Your Ref: 2024/92283

Our Ref: A004487

24th December 2024

Dewsbury Market, 32 Cloth Hall Street, Dewsbury – Redevelopment of market with addition of mezzanine floor

Appendix D: Drainage Strategy

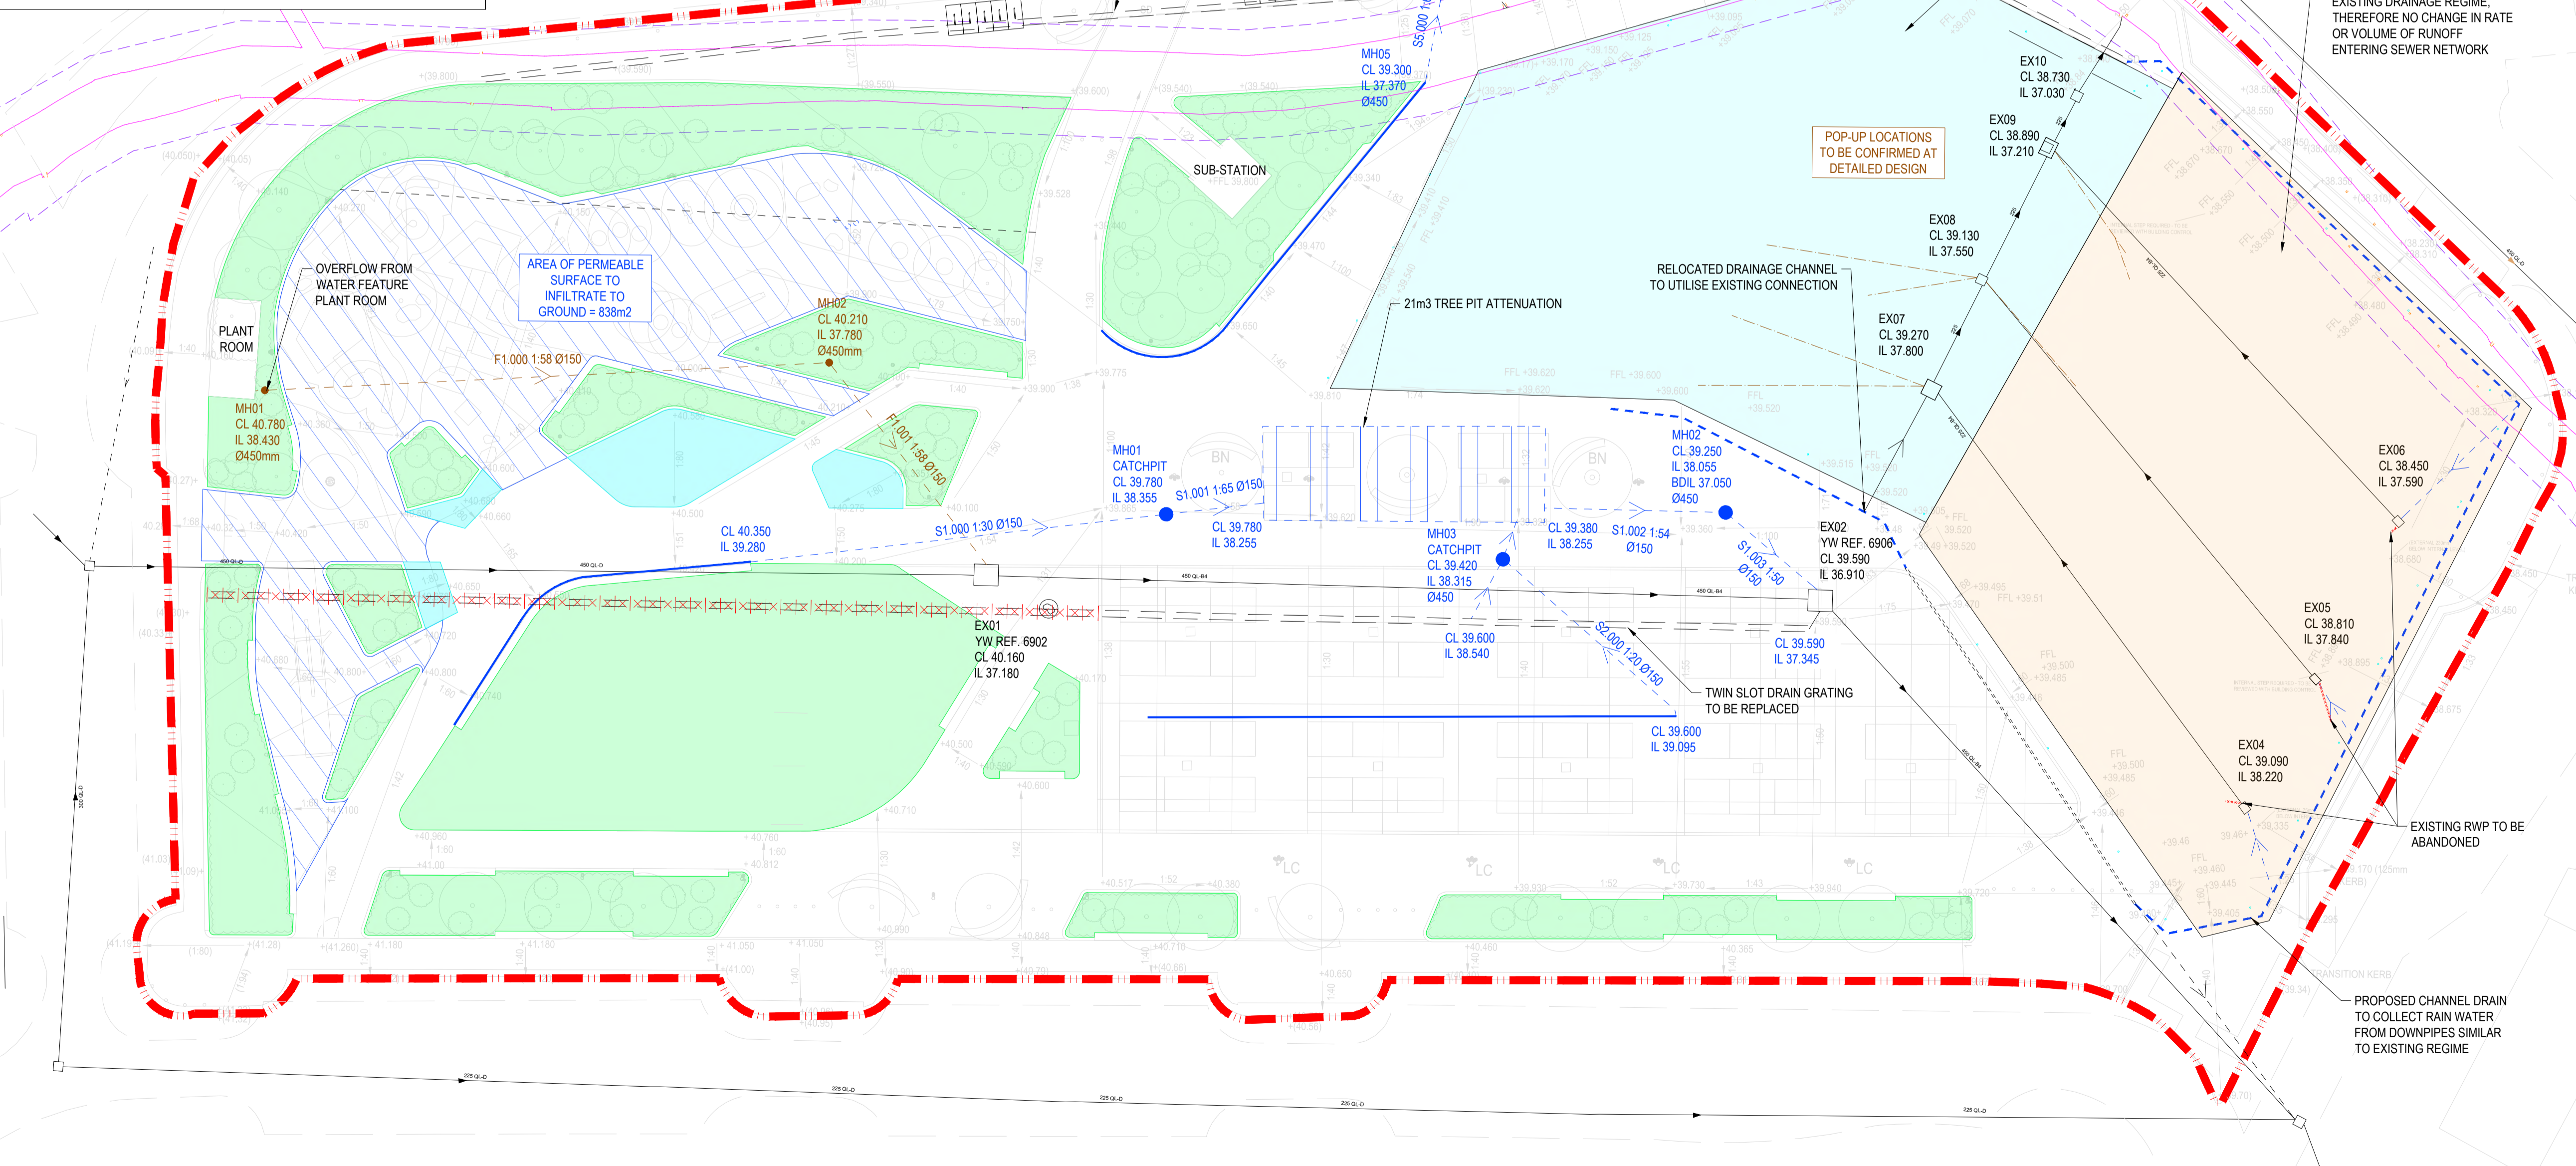
**The development shall be carried out in accordance with the details shown on the submitted plan, "Flood Risk Assessment & Outline Drainage Strategy Report' DMTP-BDP-00-XX-RP-C-00001 (rev P02) prepared by BDP, dated 12/08/24", unless otherwise agreed in writing with the Local Planning Authority.
(In the interest of satisfactory and sustainable drainage)**

- 1.) The submitted 'Flood Risk Assessment & Outline Drainage Strategy Report' DMTP-BDP-00-XX-RP-C-00001 (rev P02) prepared by BDP, dated 12/08/24 is acceptable.

- a.) Foul water will discharge to public combined water sewer.
 - a.) Surface water will discharge to culverted watercourse.
- 2.) Yorkshire Water has no objection in principle to to the layout / landscaping details submitted on drawing 'Landscape Existing and Proposed Levels Plan' DMTP-BDP-TP-SL-SK-L-90601 (rev P02) as prepared by BDP dated 07/11/24
- a.) The proposed tree planting stand-off from the public sewer
 - b.) There will be no landscaping planters directly over the line of the public sewer.
- 3.) On the Statutory Sewer Map, there is a 450 & 375 mm diameter public combined water sewer recorded to cross the site. It is essential that the presence of this infrastructure is taken into account in the design of the scheme.
- a.) It may not be acceptable to raise or lower ground levels over the sewer and we will not accept any inspection chambers on the sewer to be built over.
